**ExQ2: 03 August 2021****Responses due by Deadline 7: 03 September 2021**

| <b>ExQ2</b>  | <b>Question to:</b>                           | <b>Question:</b>  |
|--|---|---|
| <b>DCO.2 Draft Development Consent Order (DCO) – comments on the Applicants’ responses to ExQs1 (all para numbers are prefixed DCO.)</b> |   |   |

DRAWING NO:
SZC-SZ0100-XX-000-DRW-100205

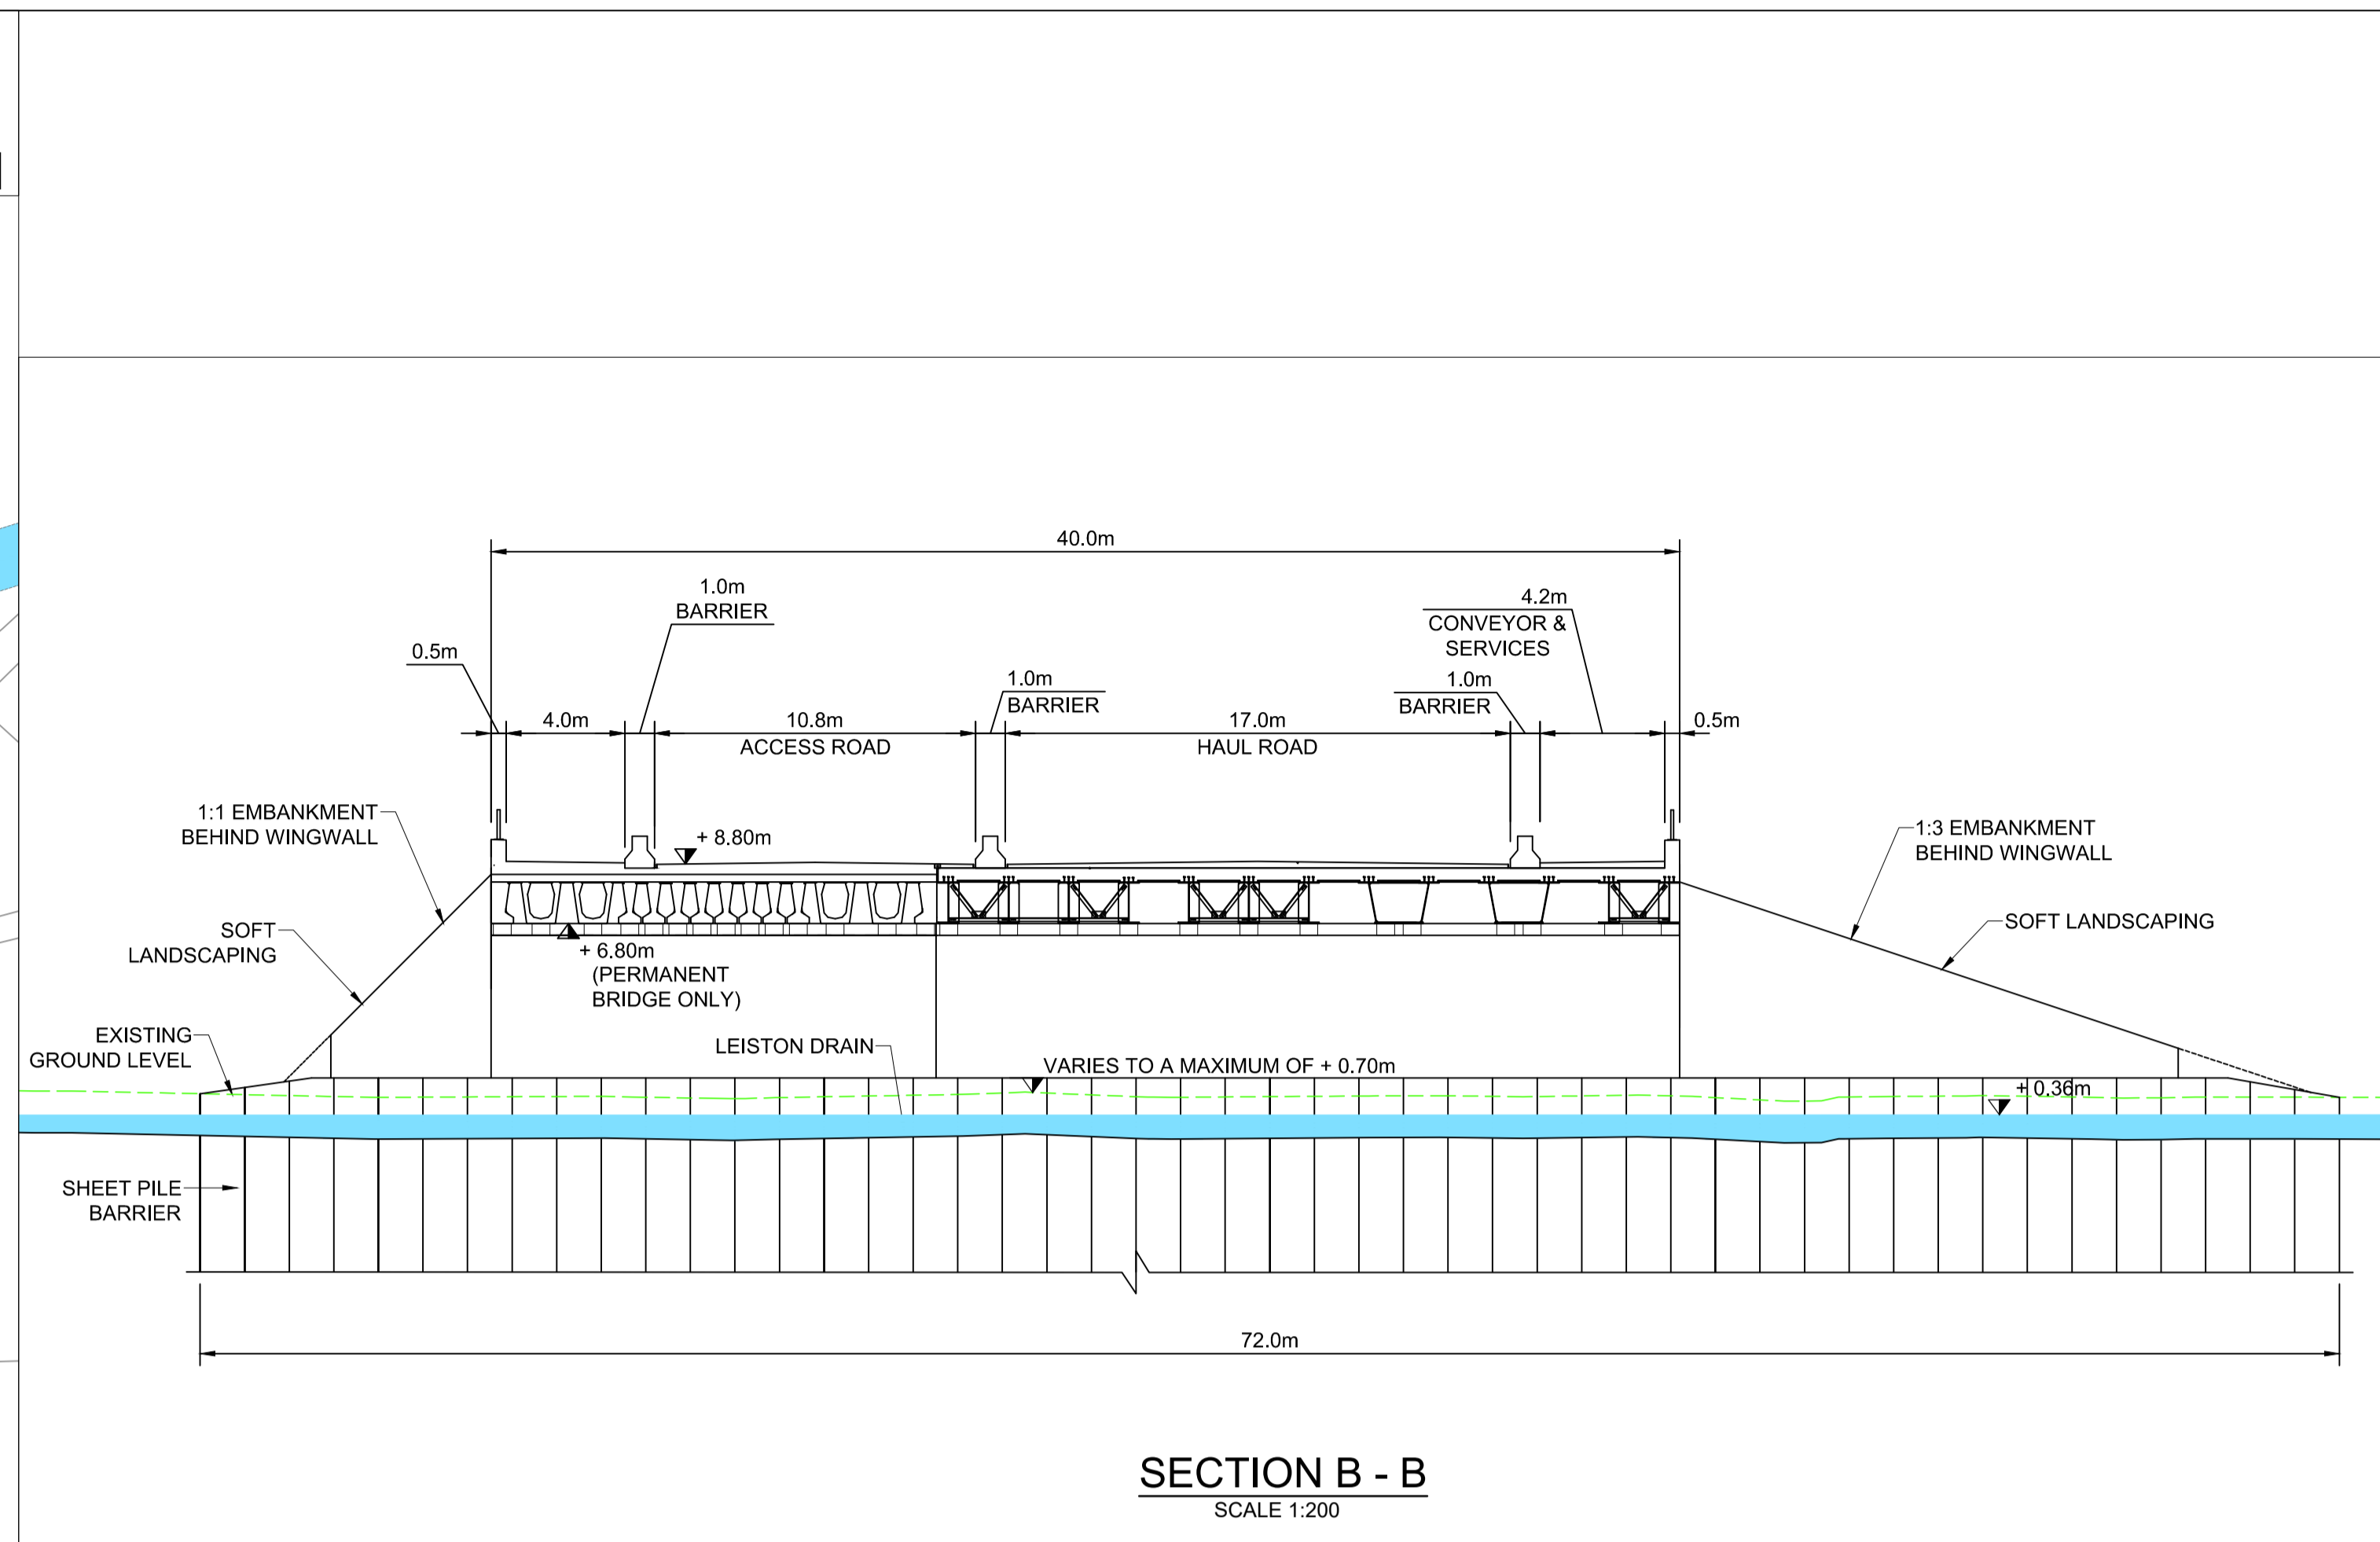
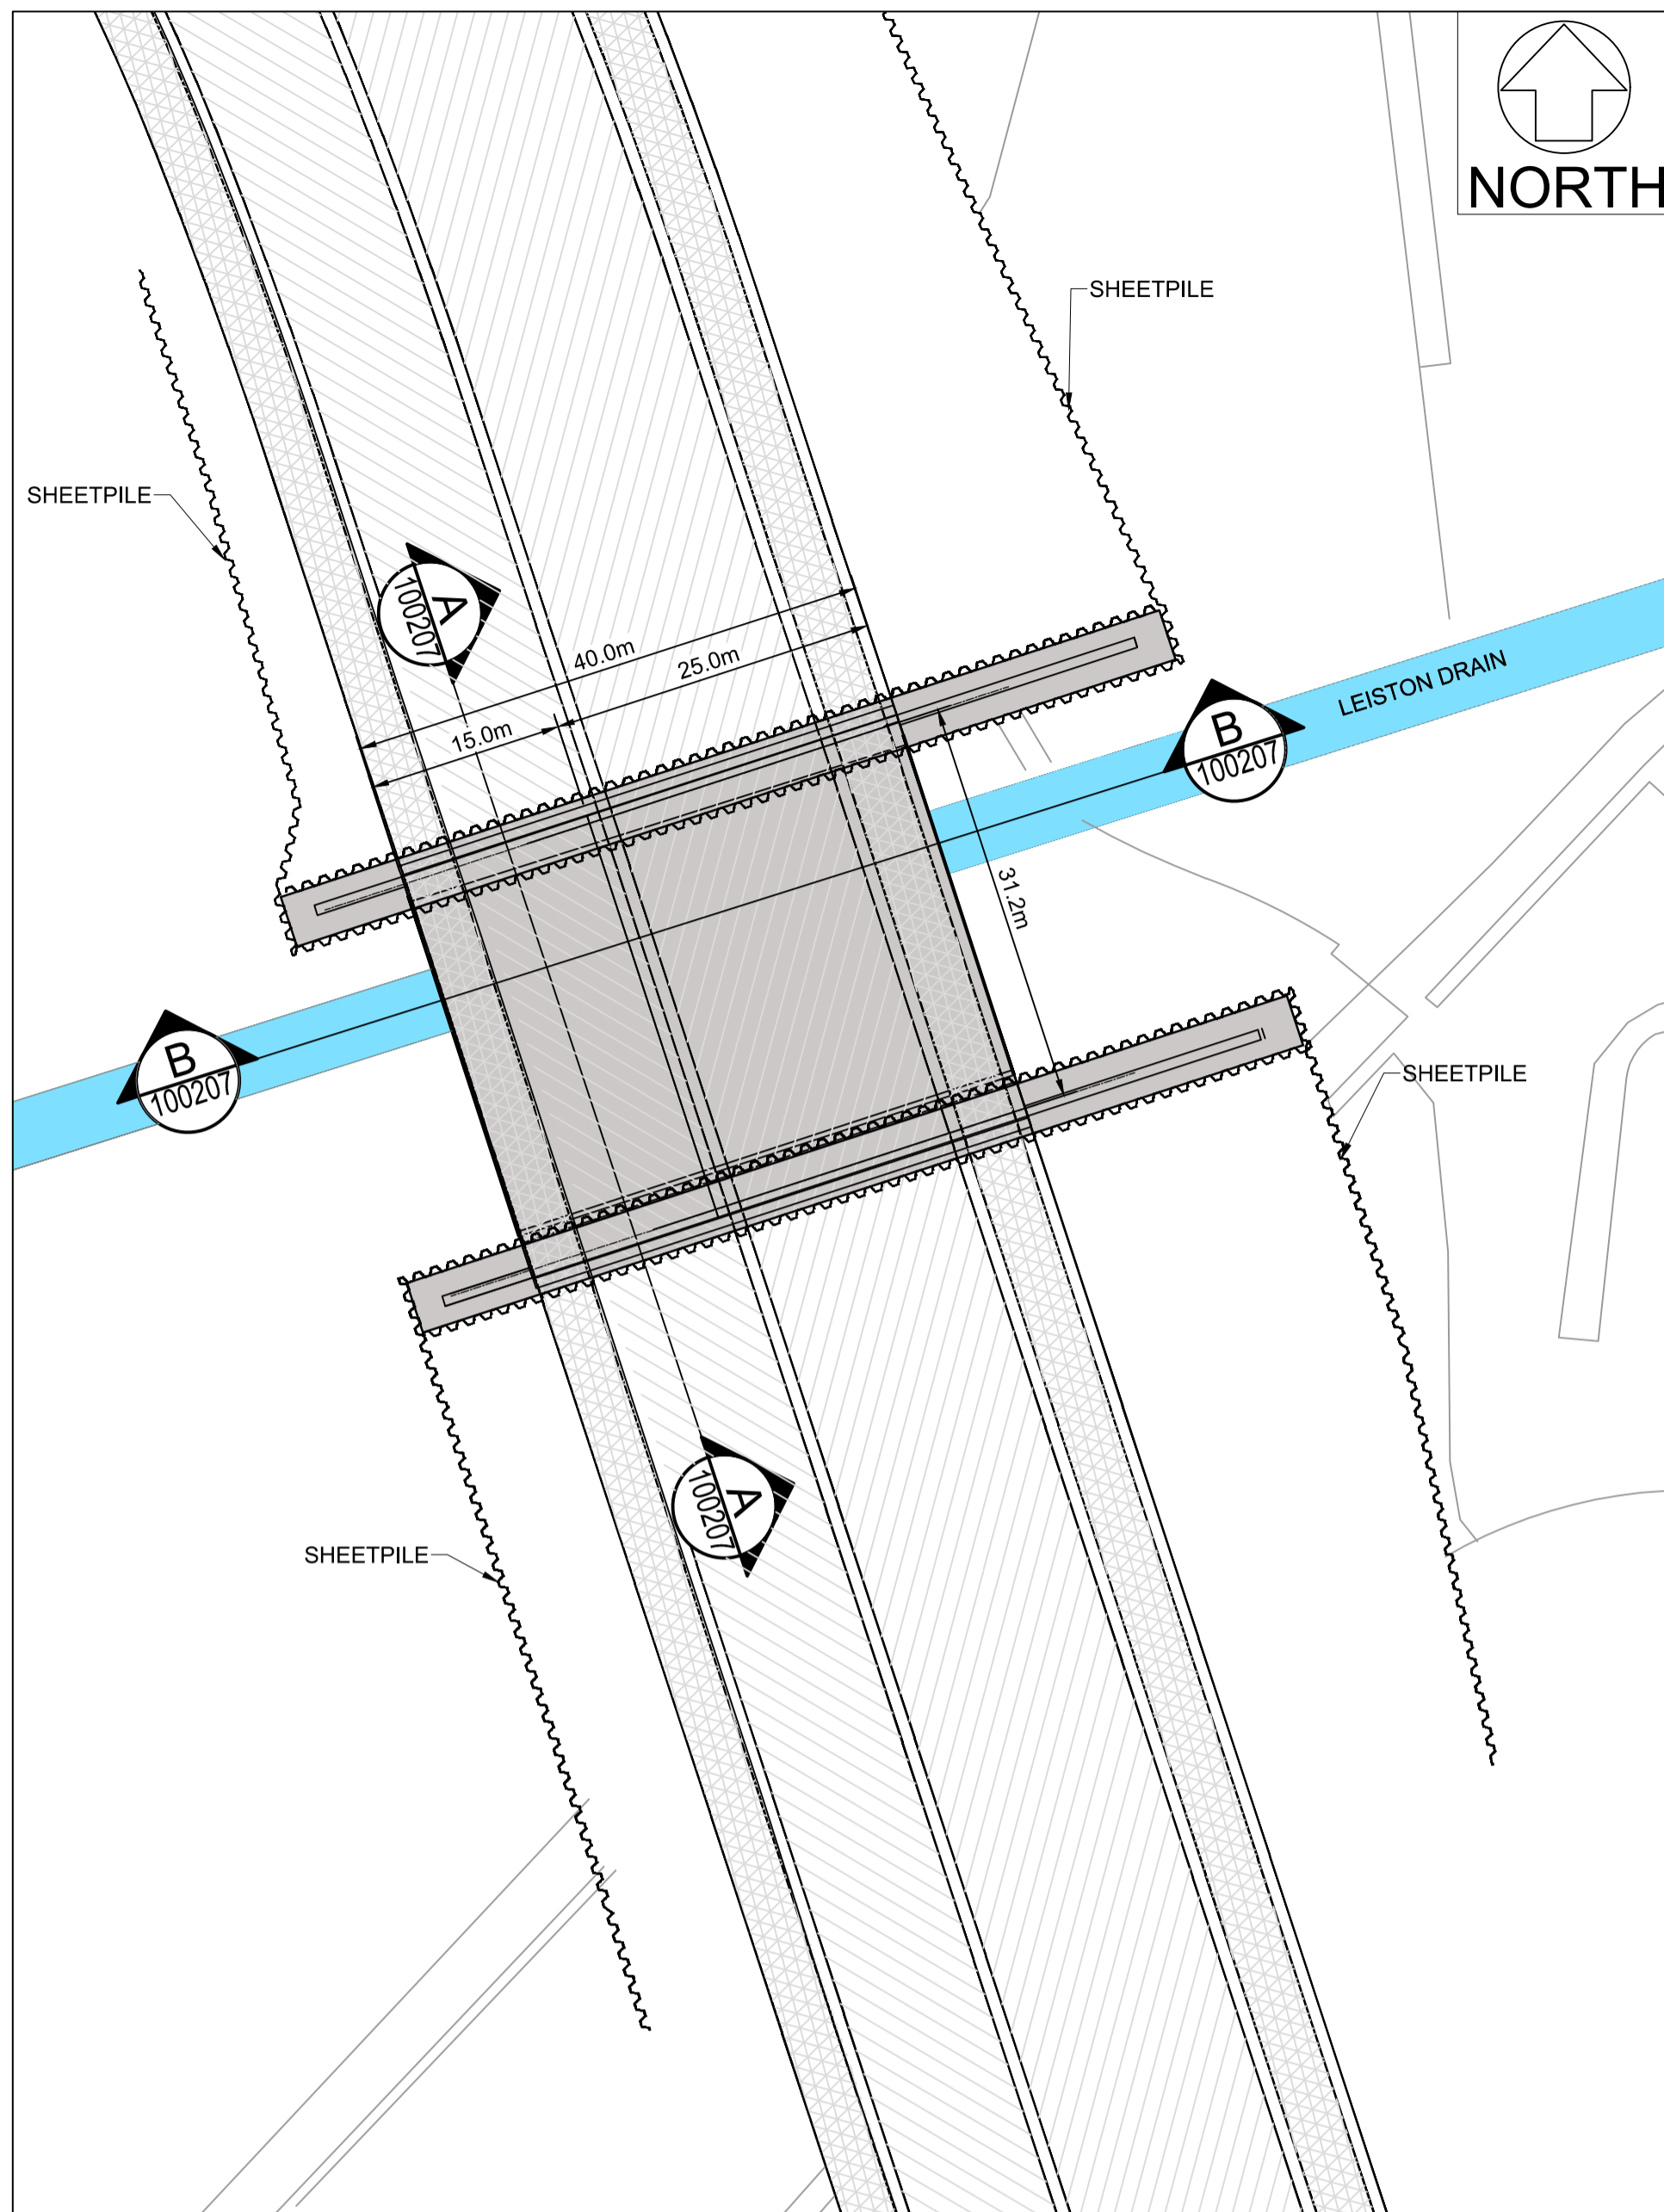
| <b>ExQ2</b> | <b>Question to:</b>  | <b>Question:</b>   |
|-------------|--|--|
| LI.2.7      | ESC, SCC, Natural England, The AONB Partnership, Stop Sizewell C, TASC | <p><b>SSSI Crossing – Design Amendment</b></p> <p>Please review the amended SSSI crossing design [REP5-010] and provide comment.</p>   |
|             | TASC response  | <p>TASC preface our comments on the SSSI crossing with our overriding opinion that the access road planned, results in too great a loss of AONB and SSSI. TASC remind the ExA that while Sizewell was listed within EN6 as a potentially suitable site, we draw attention to TASC's ISH 5 Landscape submission [REP5-296] para 15d) which says, in respect of EN6 Annex C [para C.8.69]: "The assessment expressly excluded consideration of the access road impact, indeed it says: "there is no presumption that development will take place in the area of the access road". It is the access road that results in the need for the SSSI crossing and the loss of SSSI within the AONB. Loss of SSSI cannot be said to enhance the purpose of the AONB's designation nor help with wildlife recovery.</p> <p>Regarding the SSSI crossing design in REP5-010, whilst little information is provided, the illustrations reinforce TASC's opinion that the structure is totally at odds with the setting and attributes of the AONB. The embankments have a man-made appearance so do not accord with the natural beauty of the landscape. TASC refer to EN1 para 5.9.9 which states "AONBs have been confirmed by the Government as having the highest status of protection in relation to landscape and scenic beauty." This is confirmed in the NPPF at para 176.</p> |

| <b>ExQ2</b> | <b>Question to:</b>  | <b>Question:</b>   |
|-------------|--|--|
| LI.2.8      | The Applicant  | <p><b>SSSI Crossing – Design Amendment</b></p> <p>Please confirm what assessment has been undertaken in respect of potential landscape and visual impact(s) due to the amended design of the SSSI crossing [REP5-010]. In addition, please provide visualisations which clearly depict the proposed sheet pile barrier.</p>  |
